**HYDROLOGY DEVELOPMENT SECTION
DEVELOPMENT REVIEW BOARD MEMO**

DRB PROJECT NO: 1010284

**BLOCK 33, RIDGECREST ADDN.
LOT 13 & W. 15FT OF LOT 12
(ROSS PLACE SE)**

**LOT 13-A and LOT 13-B, BLOCK 33**

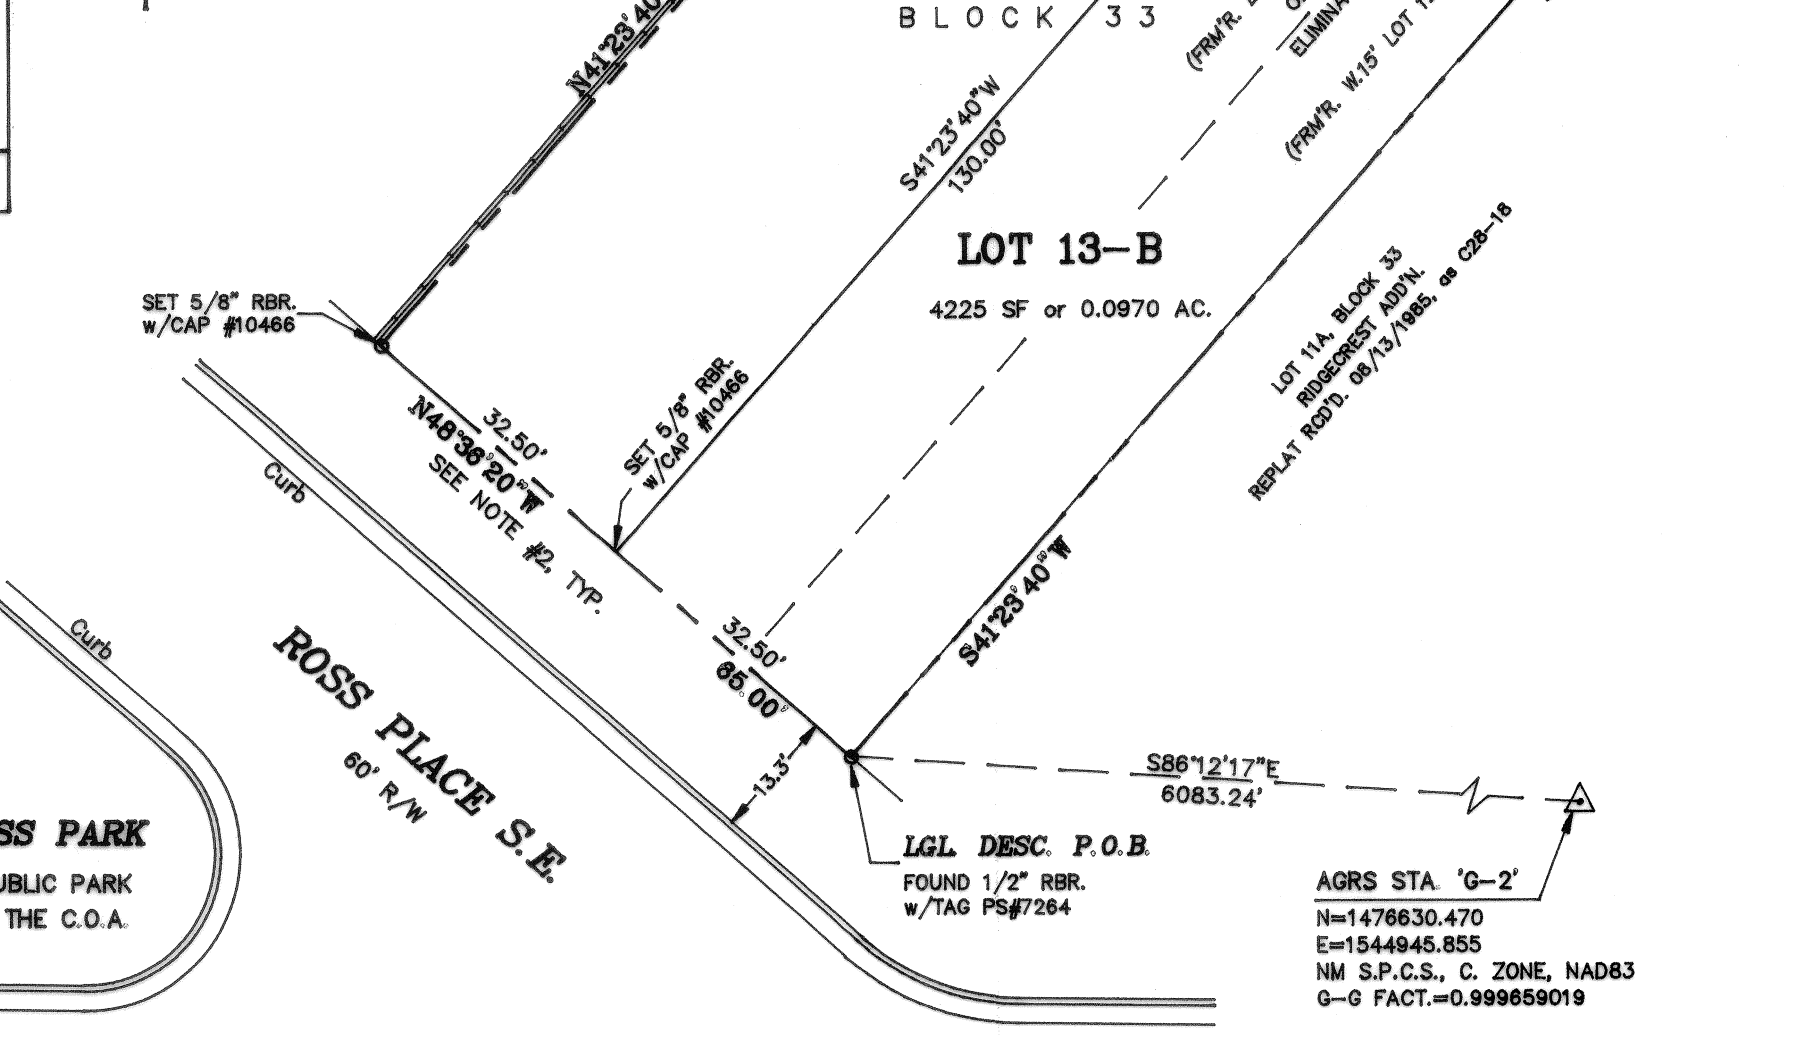
No objection to the plat.
AMAFCA Designee needs to sign plat.

When these properties develop, only historic (undeveloped) flows are allowed to drain to the property to the NE (Lot A2), unless a drainage easement is granted. The remaining runoff will have to drain to Ross Place, and the property will need to be graded to do so. Building Permit plans will have to reflect this.
